PRE-DEVELOPMENT APPLICATION COMMENTS

APPLICATION NO:	PRE0078/22																																																														
ADDRESS:	Archdale Walk (Coonanbarra Road Wahroonga) - Location of works that form part of this Pre-DA Sites below associated with the proposed works: 4-10 Neringah Avenue Sth WAHROONGA NSW 2076 12 Neringah Avenue Sth WAHROONGA NSW 2076																																																														
DESCRIPTION OF PROPOSAL:	Request for advice in relation to the re-grading of a footpath known as Archdale Walk. The works are associated with a proposed SSD for a seniors living development at 4-12 Neringah Avenue South, Wahroonga.																																																														
MEETING DATE	10 August 2022																																																														
PRESENT AT MEETING:	<table border="1" style="width: 100%;"> <thead> <tr> <th colspan="3"><i>Council</i></th> </tr> <tr> <th><i>Name</i></th><th colspan="2"><i>Title</i></th> </tr> </thead> <tbody> <tr> <td>Jonathan Goodwill</td><td colspan="2">Team Leader Development Assessment Central</td> </tr> <tr> <td>Haroula Michael</td><td colspan="2">Executive Assessment Officer</td> </tr> <tr> <td

Scale 1:50 @ A1

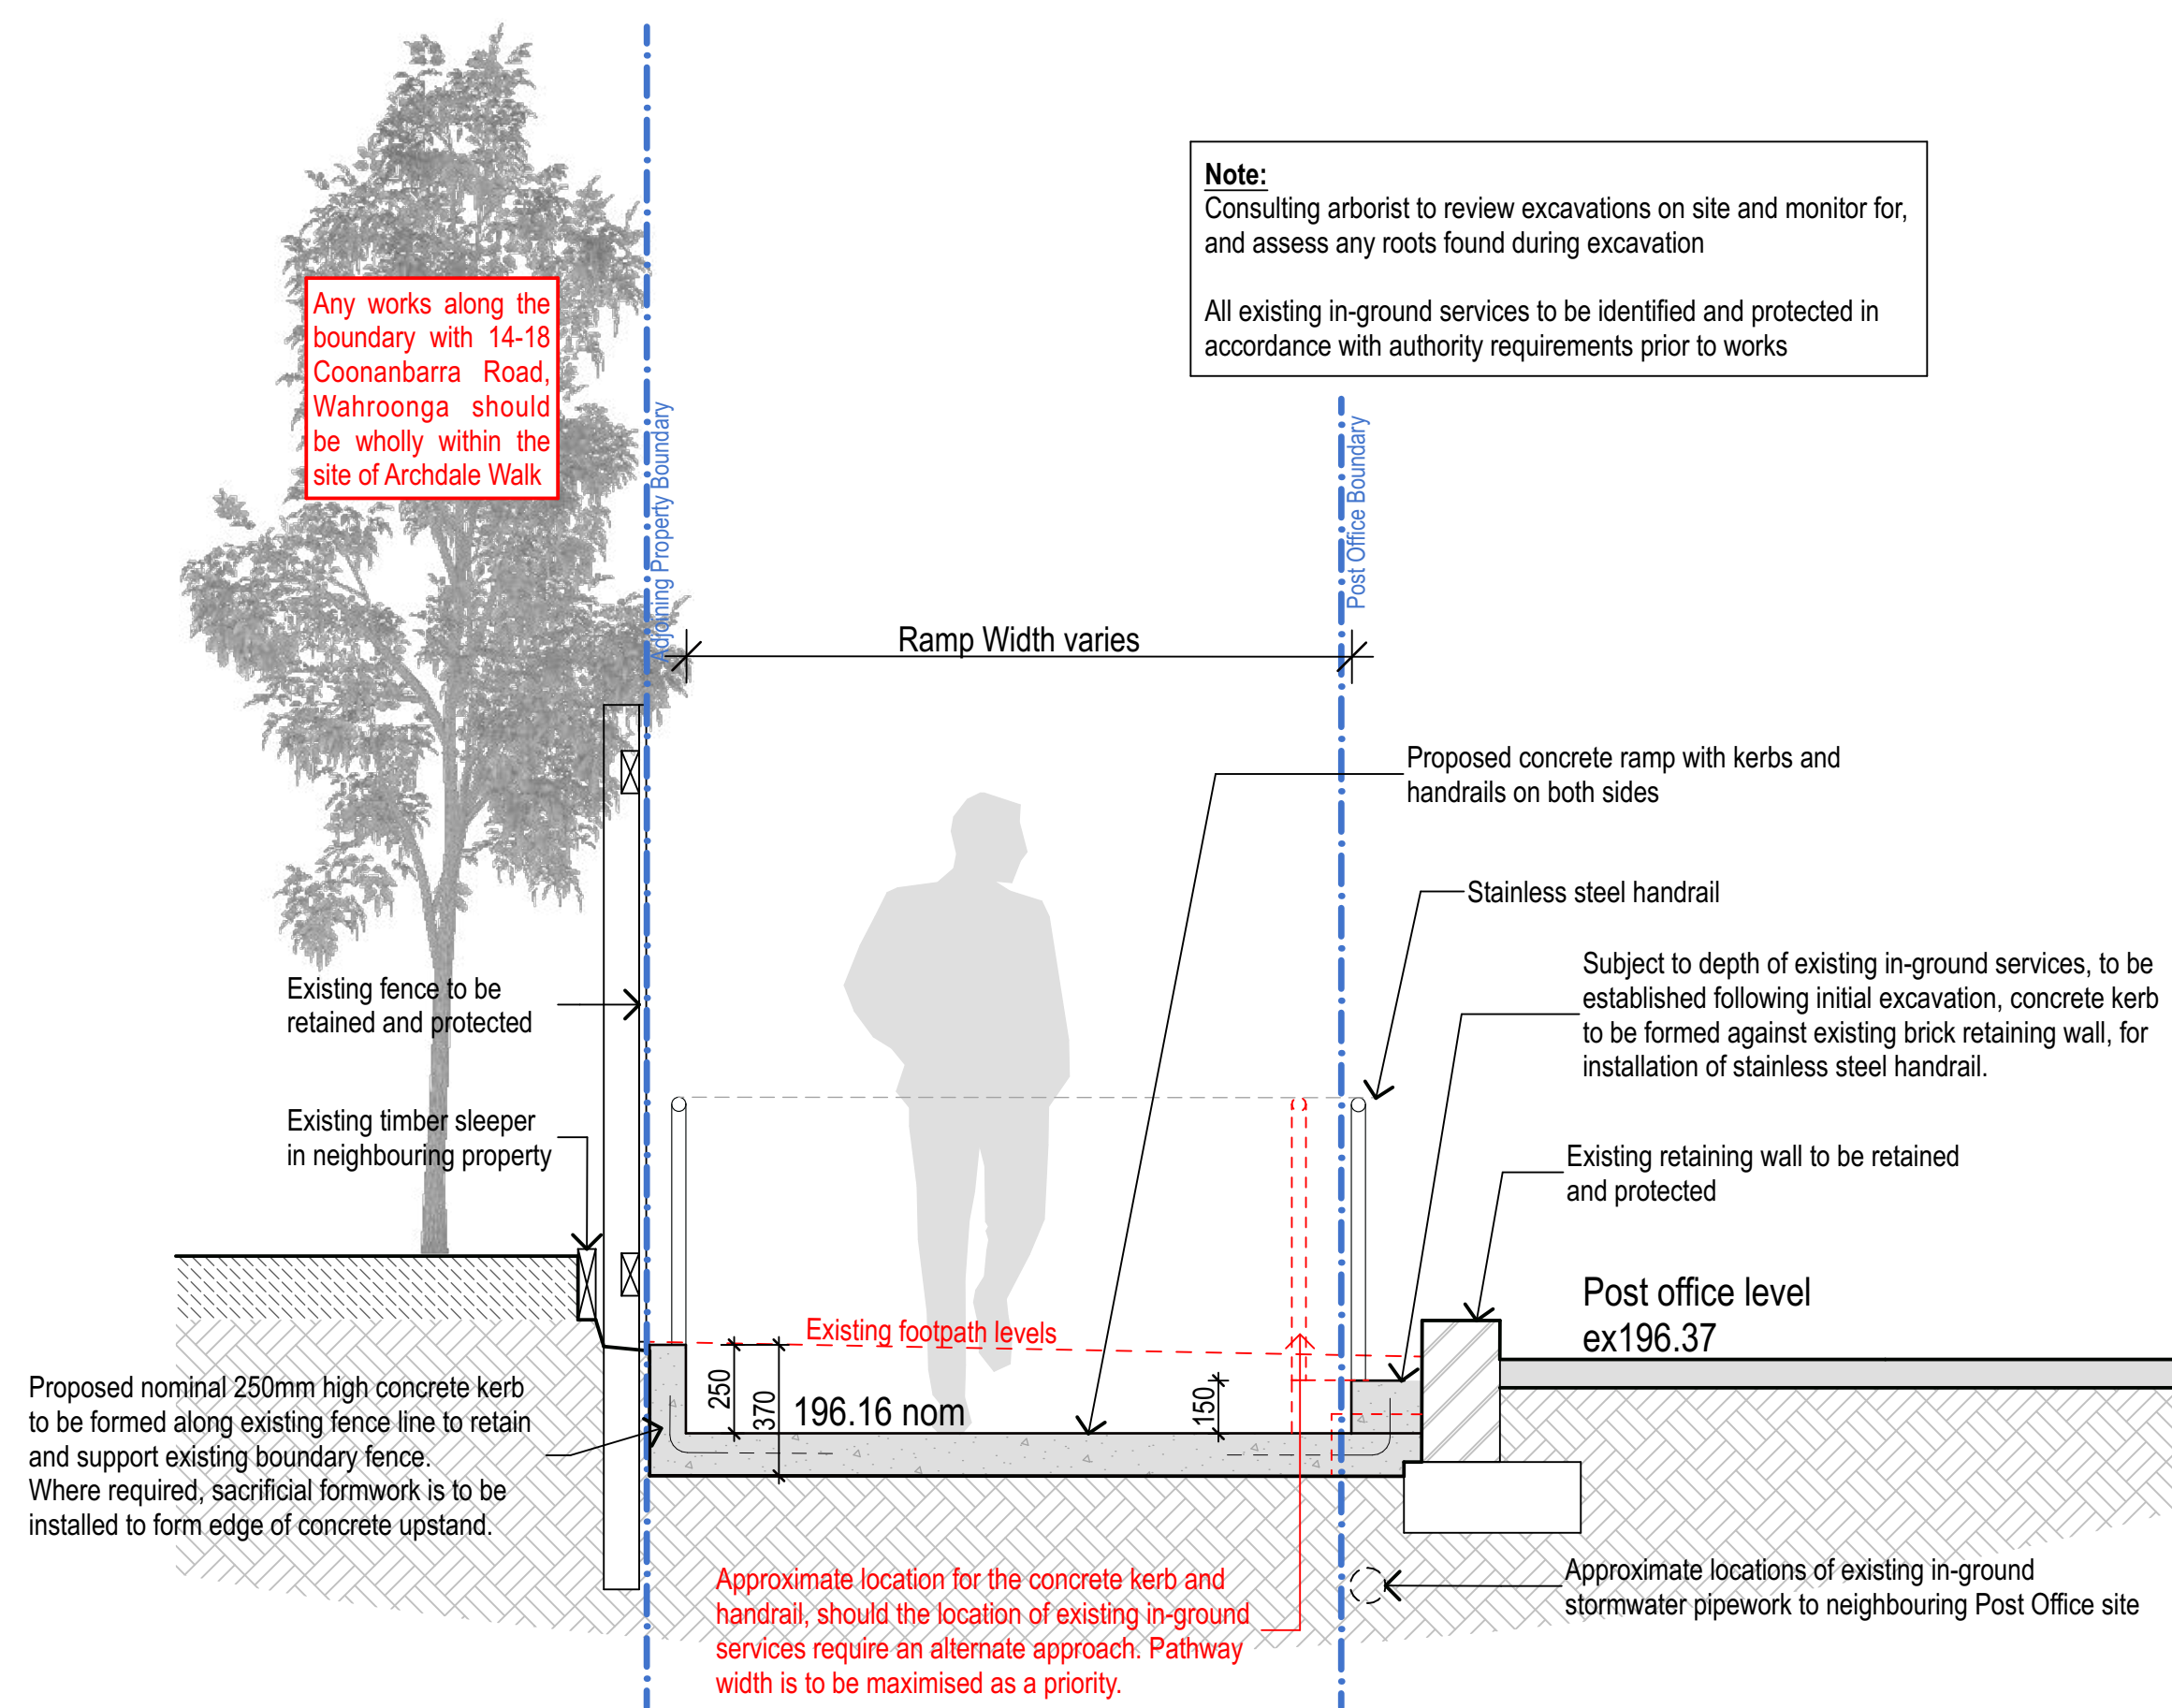
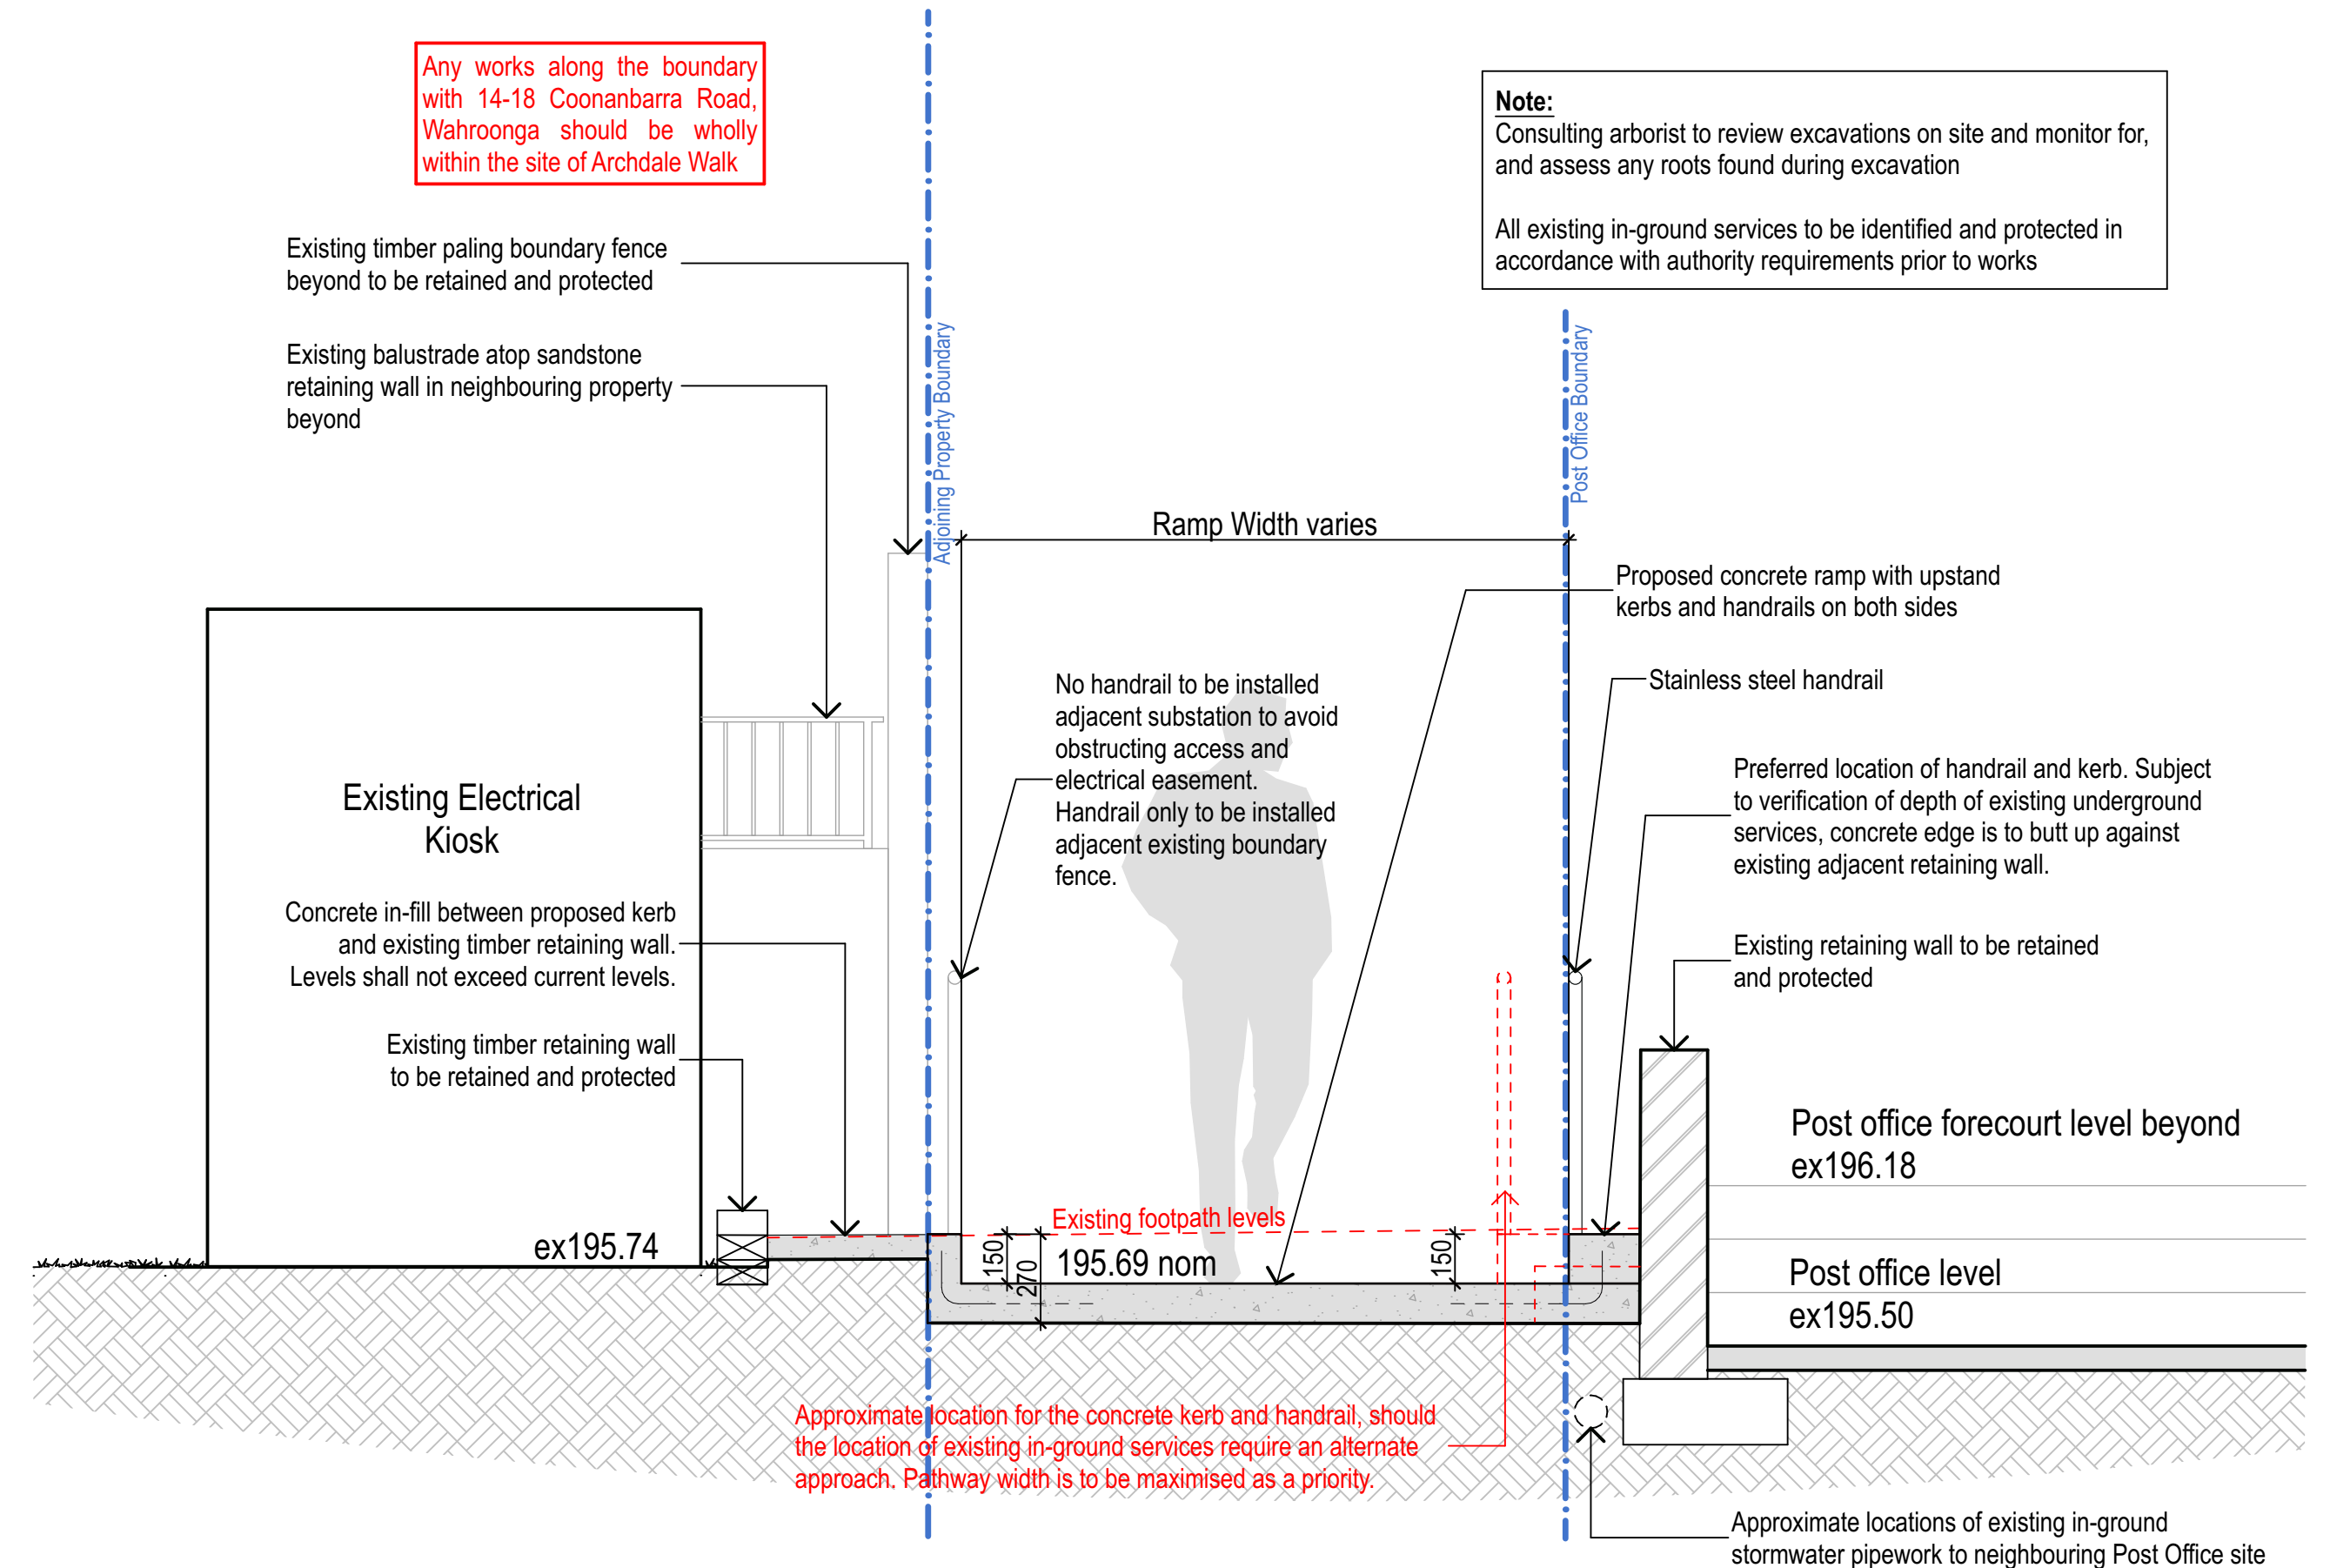
- The footpath remediation works to be generally in accordance with Drawing No. LA-DG-80-A0/A and LA-DG-81/A' prepared by Arterra Design Pty Ltd.
- The location of all underground services as well as drainage, including levels and any adjustments to existing underground services are to be shown for setting out for construction.

- The access consultant must endorse the plans to ensure compliance with the accessible walkway, ramps and landings under AS1428.1-2009.
- Any detail design will need to account for the roof water drainage for the post office which is currently under the path.

- In regard to the brick wall along the post office boundary, where the existing gap in the brick wall is to be filled, the infill portion of the wall should be approx. mid height between the 2 existing walls. The new wall as shown in the drawings is a potential trip hazard from Post office path level.

- The laneway width should be as consistent as possible. The eastern section of the footpath should not have 2 levels as the "step" between the brick retaining wall and the new footpath appears to be 'leftover' land and is not a good design outcome. The new footpath level should continue right across laneway up to the brick retaining wall, unless it can be proven that services or subsurface conditions prohibit this from being possible. If is not possible, then another design solution must be explored. If it is possible, then the hand rail is to run along the edge of the path.

- The end of the hand rail should not extend into footpath area along Coonanbarra Road.
- A detail of the treatment between substation and new path levels, as well as details of changed levels is to be provided.
